Rezoning Transportation Analysis

Petition Number: 2023-030

General Location Identifier: 05113204,05142102,05142111

Date	Description
5-24-23	First Review (DR)
6-21-23	Second Review (DR)

Project No: 23-CLT-004
Date: January 16, 2023
Designed By: UDP
Checked By: UDP
Sheet No:
RZ-1.0

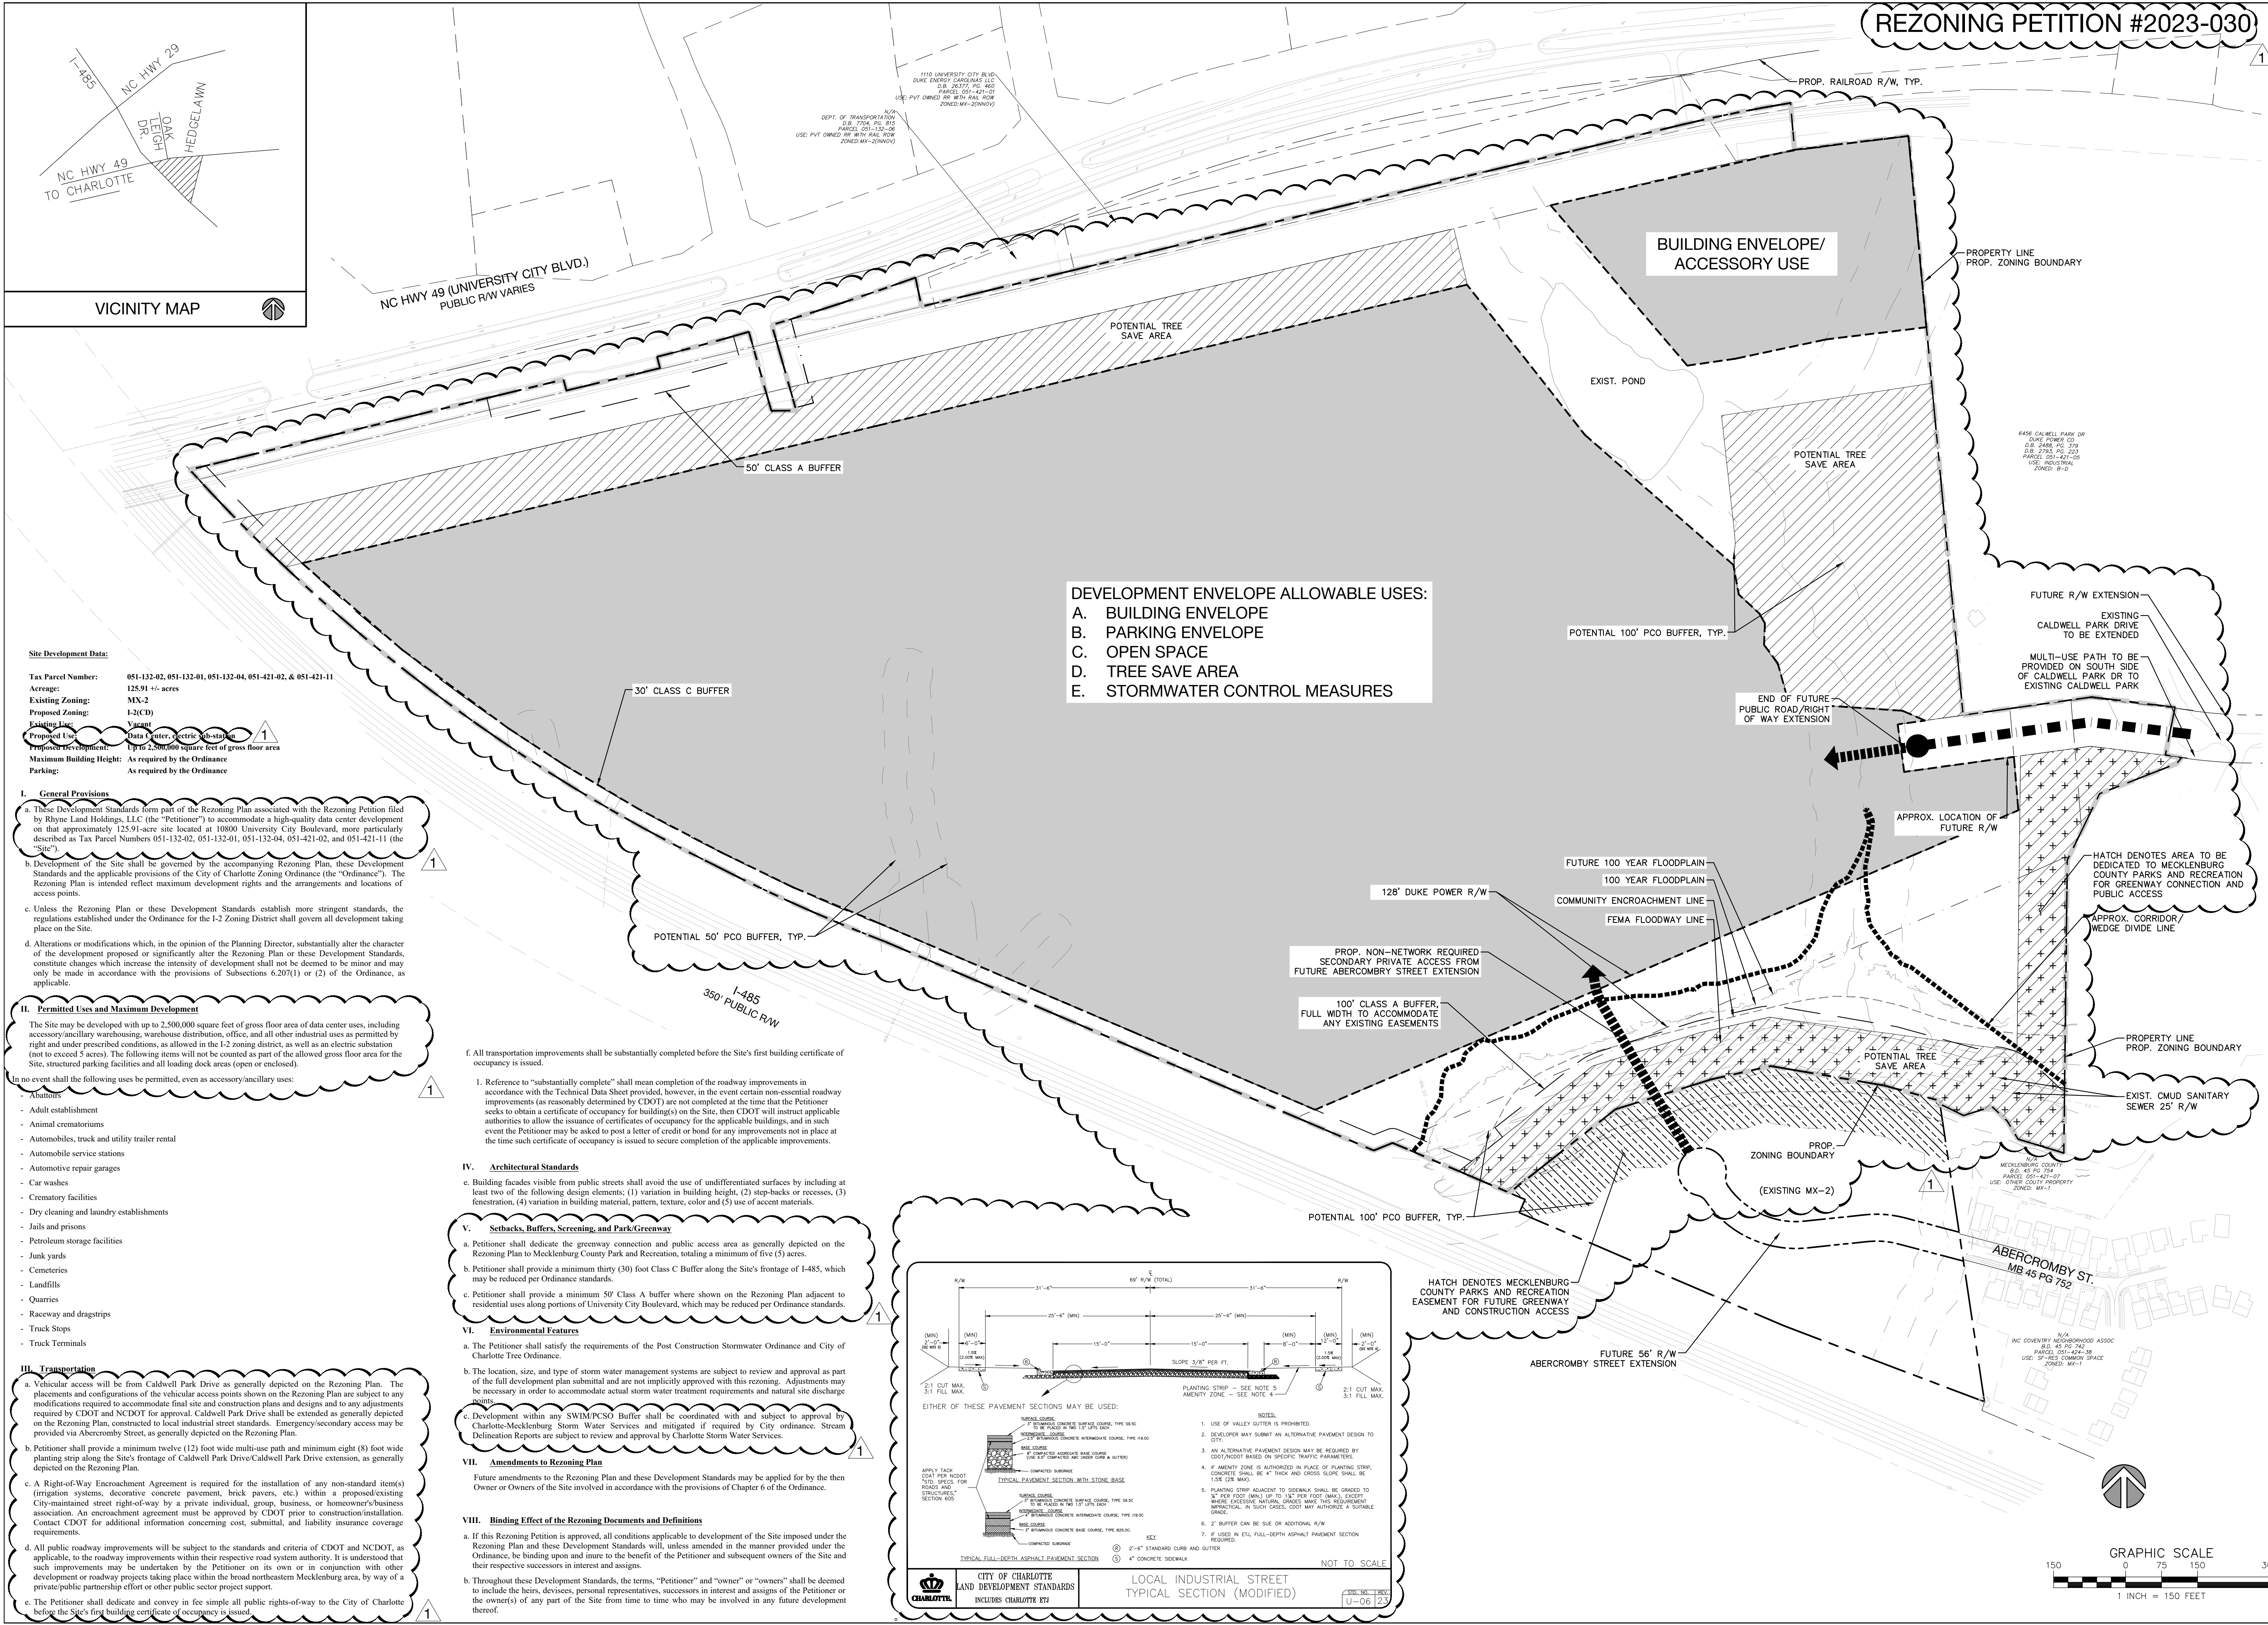
2. Remove the connection to Abercromby Street.

Clarifying comment 6.21.2023: Add conditional note that Abercromby Street will include a Knox box and will be an emergency/secondary access.

3. Add conditional note(s) committing to extend Caldwell Park Drive and upgrading to a local industrial street standard to accommodate the increased truck traffic.

Clarifying Comment 6.21.2023: Add conditional note for CLSDM Local Industrial Street (U-06) for the Caldwell Park Drive extension.

4. Add conditional note that petitioner shall construct bicycle facilities by installing a 12' multi-use path with an 8' minimum planting strip along Caldwell Park Drive. The proposed multiuse path should be extended along the southern side of Caldwell Park Drive to the northwest corner of Parcel ID 05114117 owned by Mecklenburg County.

Clarifying Comment 6.21.2023: Label and dimension streetscape elements (12' multi-used path and 8' planting strip) along Caldwell Park Drive/Caldwell Park Drive extension.

8. Add a conditional note specifying "the Petitioner shall dedicate and convey in fee simple all rights-of-way to the City before the site's first building certificate of occupancy is issued. CDOT requests rights-of-way set at 2' behind back of sidewalk where feasible."

Clarifying comment 6.21.2023: Add conditional note about CDOT requests rights-of-way set at 2' behind back of sidewalk where feasible.
